Mr G E and Mrs A P Mathias
16 Tamarisk Way
East Preston
BN16 2TF

8th April 2015

Objection to **EP/26/15/HH 14 Tamarisk Way**
Front Extension To Form Attached Double Garage

DRAWING TITLE:
South & West Elevations plus Sections
AA & BB as Proposed

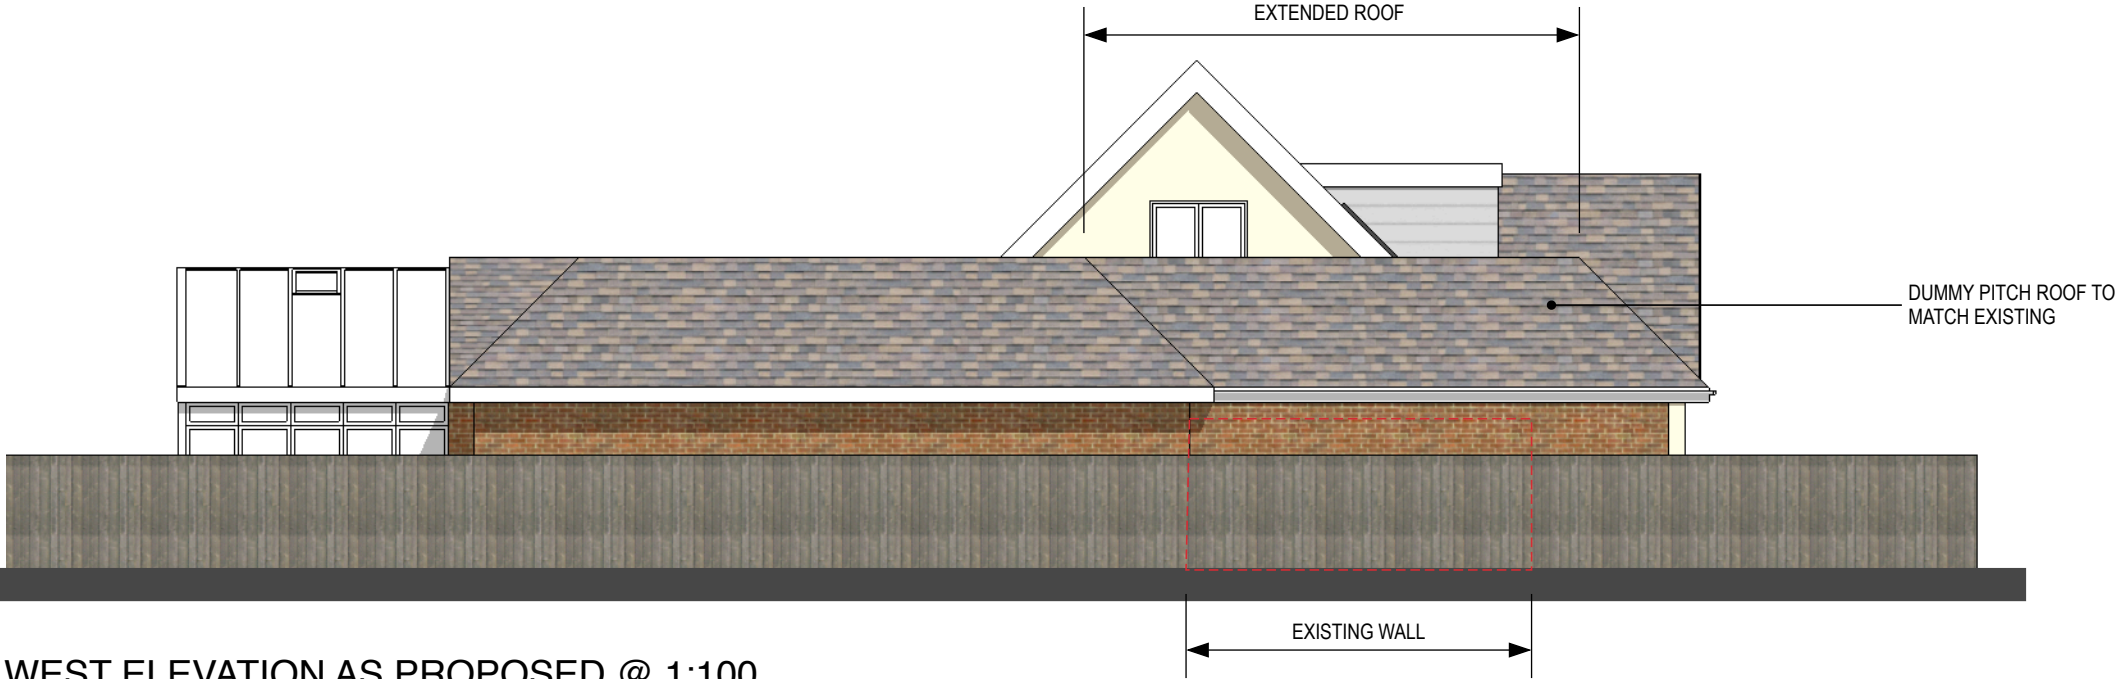
The current proposal (EP/26/15/HH) does not include a bedroom over the double garage and this does reduce the overall height of the extension from 6 to 4.2 m. However, all the other details are the same, ie the extension would still be built almost on our boundary and its length is still 6.5 m (greater than the gap between the rear of our property and the existing garage) so the whole gap on our boundary would be filled in by an extension 4.2 m high. The distance from the Eastern wall of our house to the Eastern boundary of our property is approx 1.2 m (not 2.5 m as quoted in the case for LPA refusal of EP/61/14).

We do not believe the reduction in height would significantly reduce the harmful impact of the extension on our living conditions as it would still be being dominating, overbearing and overshadowing. We are able to judge the effect of an extension of this height on our boundary because the existing extension is this height (but fortunately it is 6 m away from our house) and if we stand by the existing extension we know what it feels and looks like.

We spend a lot of time in the back of the house and our kitchen window is only about 2.1 m from our boundary and the view will be dominated by the extension. Our patio runs almost the length of the back of our house and the proposed extension would adjoin the East end of the patio and our patio would be dominated by the extension for the whole of its depth. At the West end of the patio is a conservatory and the view from the conservatory would be the wall and roof of the extension. Because the extension is to be built almost on our boundary it is not possible to mitigate or soften its impact on our living conditions m.

on the western boundary. The dimensions and location of the proposed extension would then cause unacceptable residential effects set within this spatial context. If viewed from the road from anywhere other than looking directly down our Eastern boundary the two dwelling would appear to be touching as the gap will be little more than 1.2 m.
